Recommendation Report for Planning Permission for Works or Extension to a Dwelling

REF NO: Y/47/26/HH

LOCATION: Flints
Hoe Lane
Flansham
PO22 8NP

PROPOSAL: Part single, part two-storey rear extension, and alterations to fenestration.

Proposed East Elevation

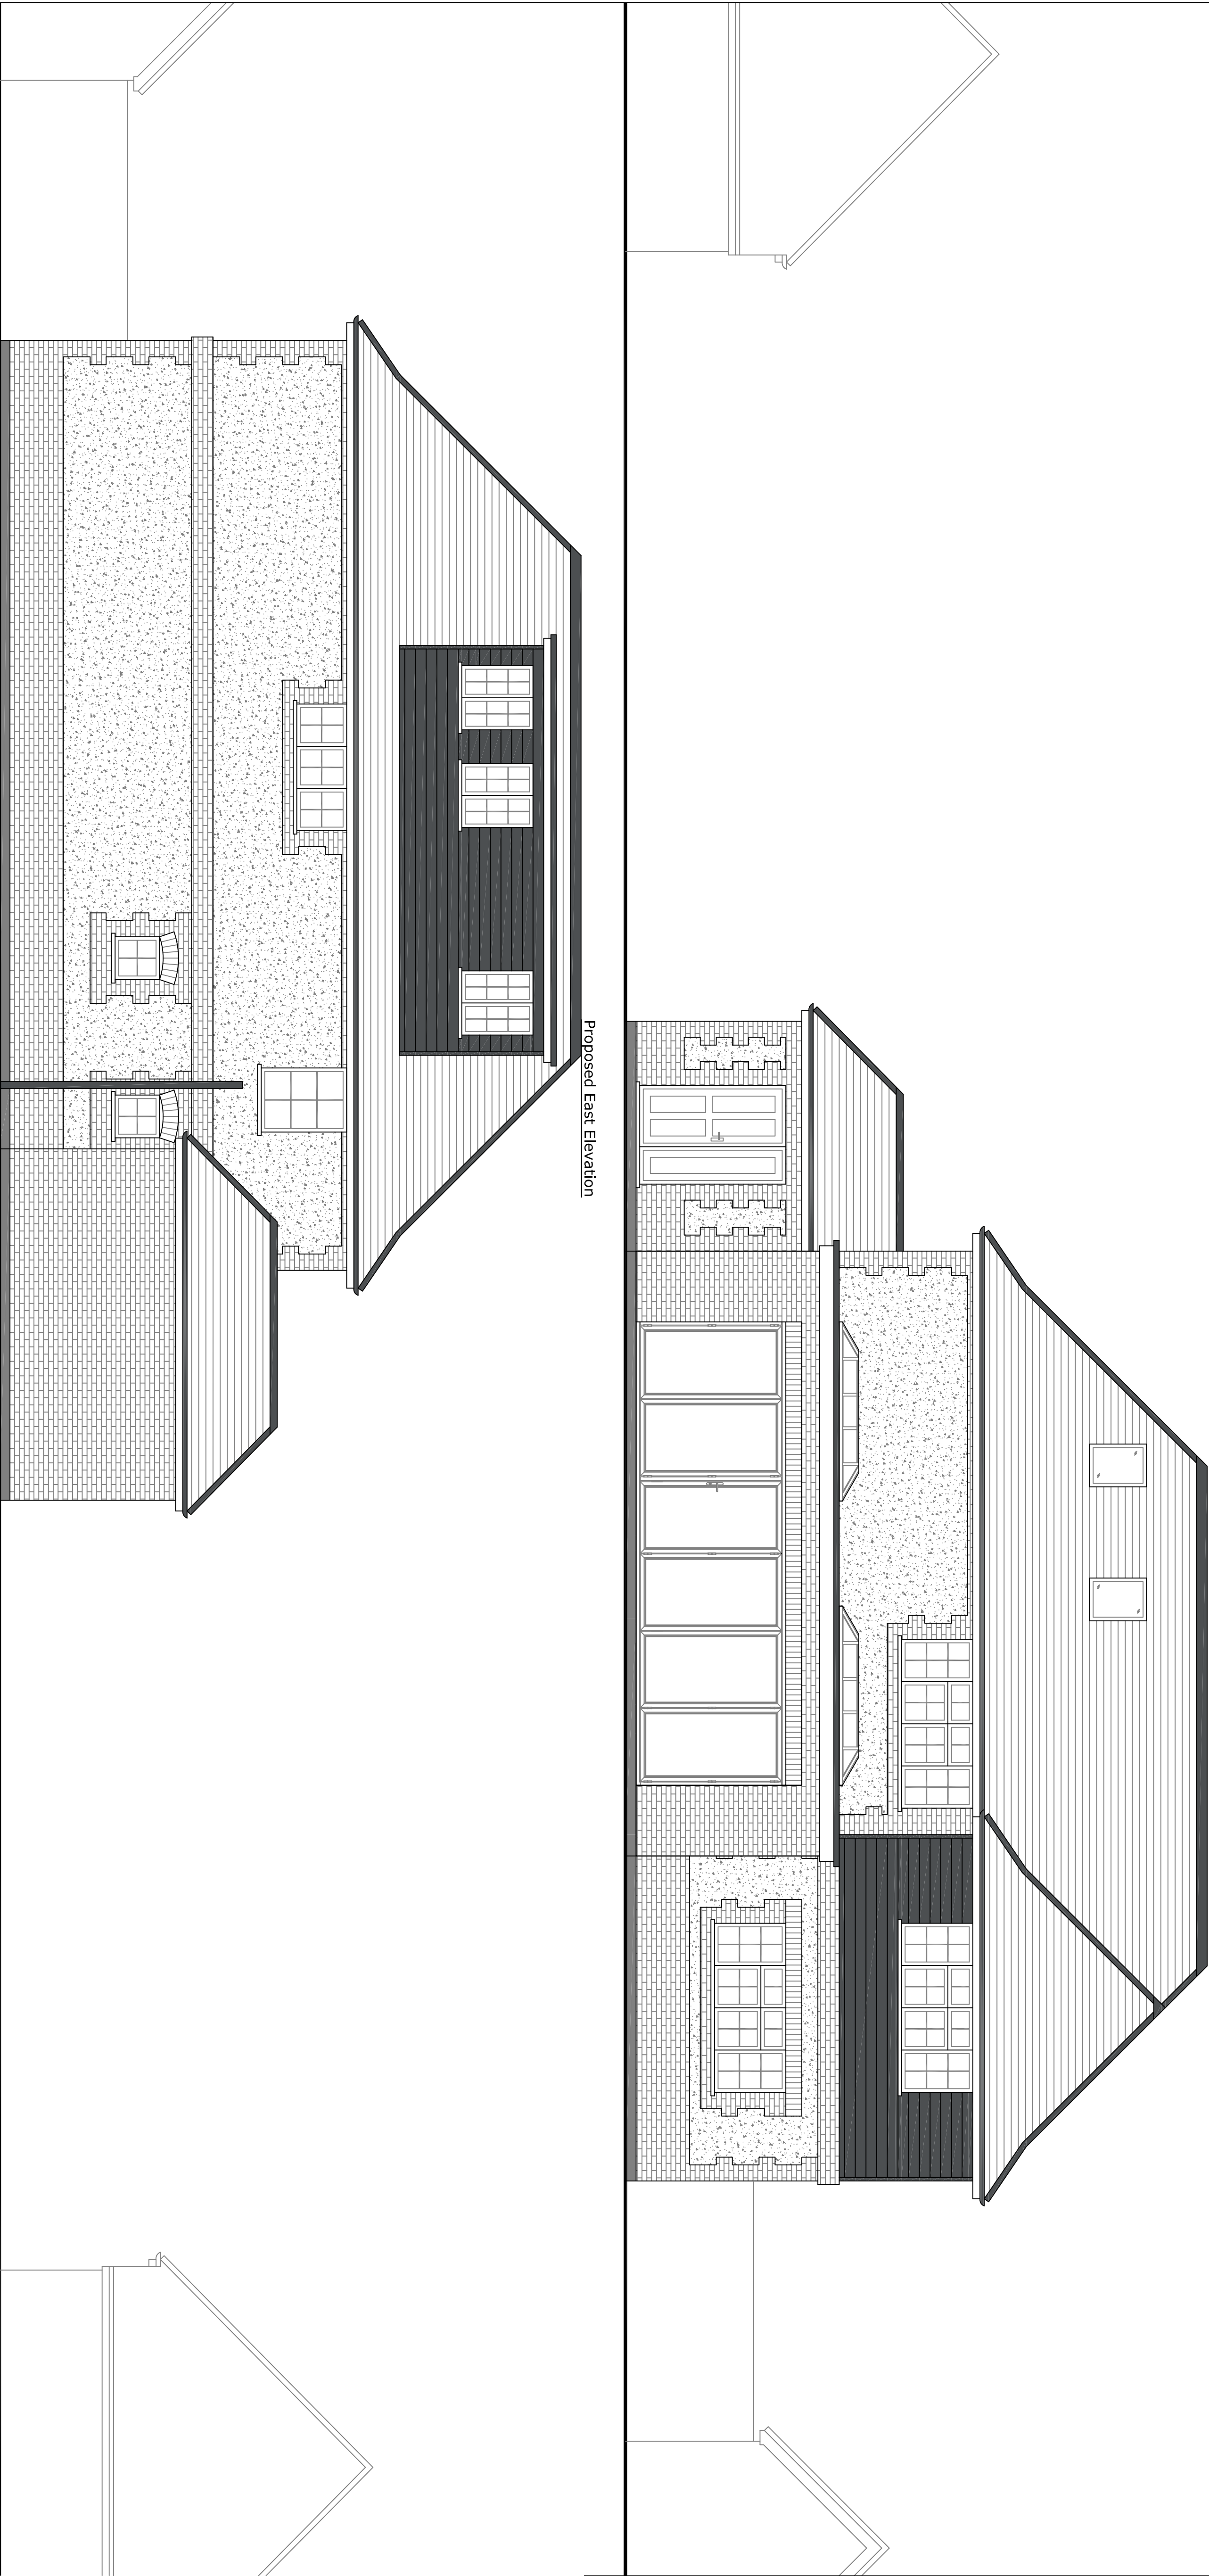
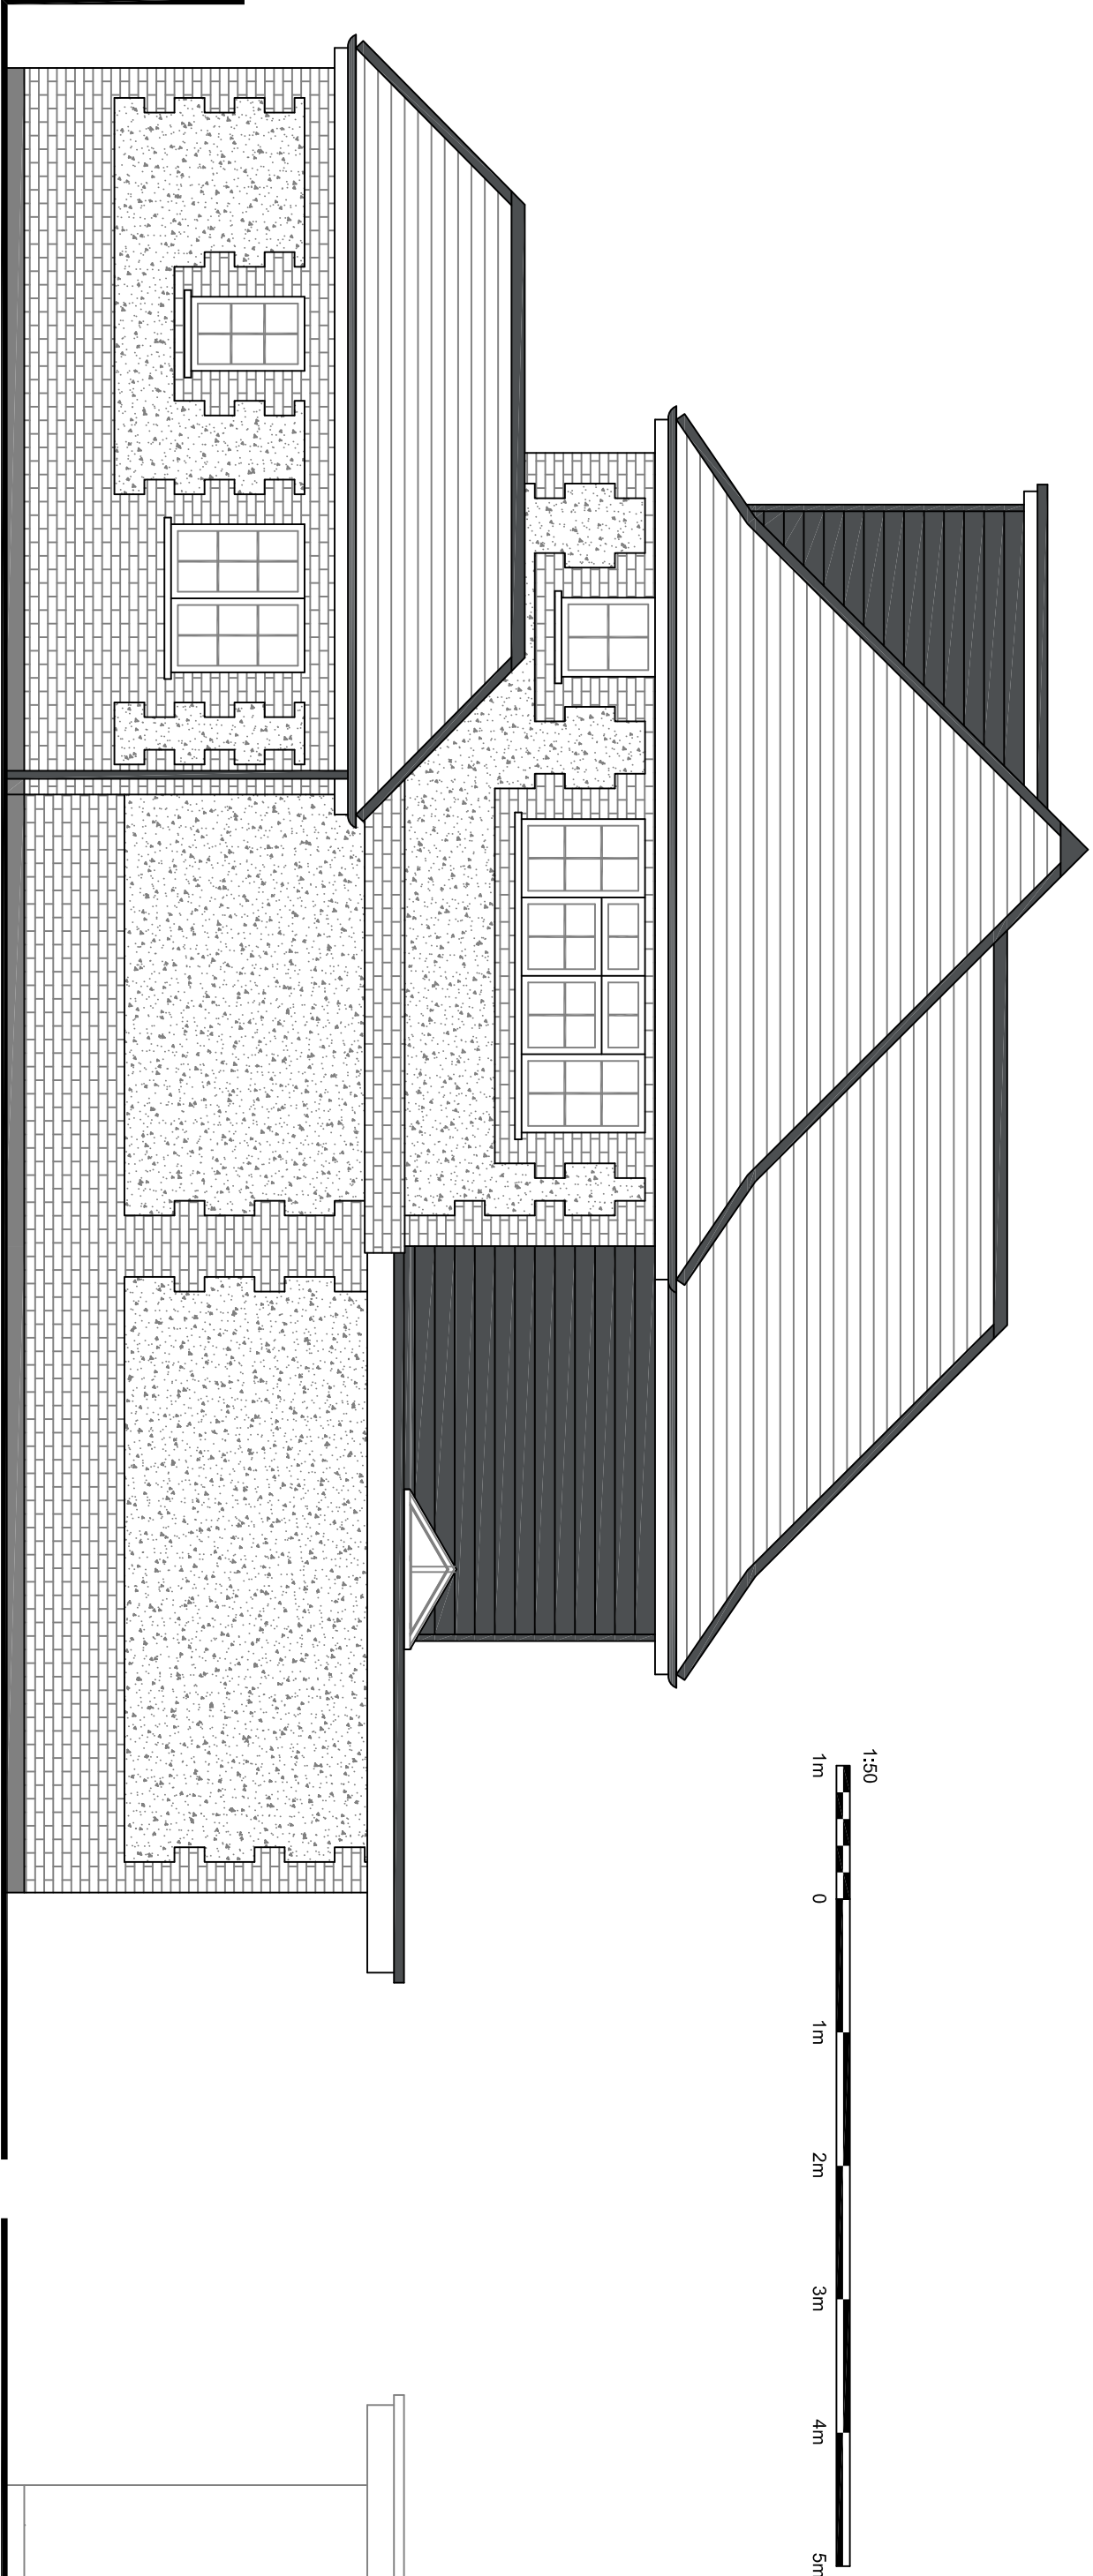
The proposed single-storey rear extension would measure approximately 4.8m in depth and 8.5m in width, partially adjoining the existing rear projection. It would have a flat roof form with a maximum height of approximately 3.3m, inclusive of lantern roof lights. External materials would comprise brickwork and flint to match the existing dwelling, in accordance with the guidance contained within the Arun Design Guide (ADG).

The extension would include large bi-fold doors within the rear elevation and two centrally positioned lantern rooflights. Whilst the design would have a more contemporary appearance than the host dwelling and exceeds the ADG guideline depth of 3.3m for single-storey rear extensions, the extension would remain proportionate to the existing property. Due to its siting to the rear, it would not appear visually prominent and would not be visible from the street scene. As such, it would not result in harm to the character or appearance of the dwelling or the surrounding area.

The first floor extension would measure approximately 4.7m in width and 3m in depth, extending over the existing rear projection. The extension would be finished in anthracite-coloured cladding, differing from the materials approved under application Y/53/25/HH. However, the cladding would complement that already used on the recently constructed dormer extension and, due to the rear location of the

The first floor extension would increase the bulk and massing of the roof form, although it would not exceed the existing ridge height. The first floor extension would replace an existing catslide roof form, however the hipped roof form of the first floor extension would reflect the character and appearance of the host dwelling and the proposal would be of a size and scale that would be a subservient addition to the host dwelling. The proposed first floor extension would not result in harm to the visual amenity of the host dwelling, street scene or wider area.

The proposed fenestration alterations include new openings within the existing rear (east) projection and within the first-floor extension, together with the installation of French doors within the side (north) elevation. Existing windows within the ground-floor rear section of the south elevation would be removed and blocked up. All proposed windows and doors would be designed to match the appearance of the existing fenestration and would be acceptable.

The single storey extension would be set in approximately 13m from the boundary with the north (side) neighbour, Bonhams. There are large scale windows proposed to the east elevations, but as these windows would have an outlook of the rear garden, the proposed extension would not result in increased overlooking impacts. As a result of its scale and siting, this element would not result in any overbearing, overshadowing, or overlooking, and would not result in harm to residential amenity.

There are proposed alterations to fenestration including a set of patio doors within the north elevation, serving the rear garden of the host dwelling. 1 No. window is removed from the south elevation and 2 No. windows are introduced within the east elevation. Both would serve the rear garden and would not result in increased overlooking impacts.
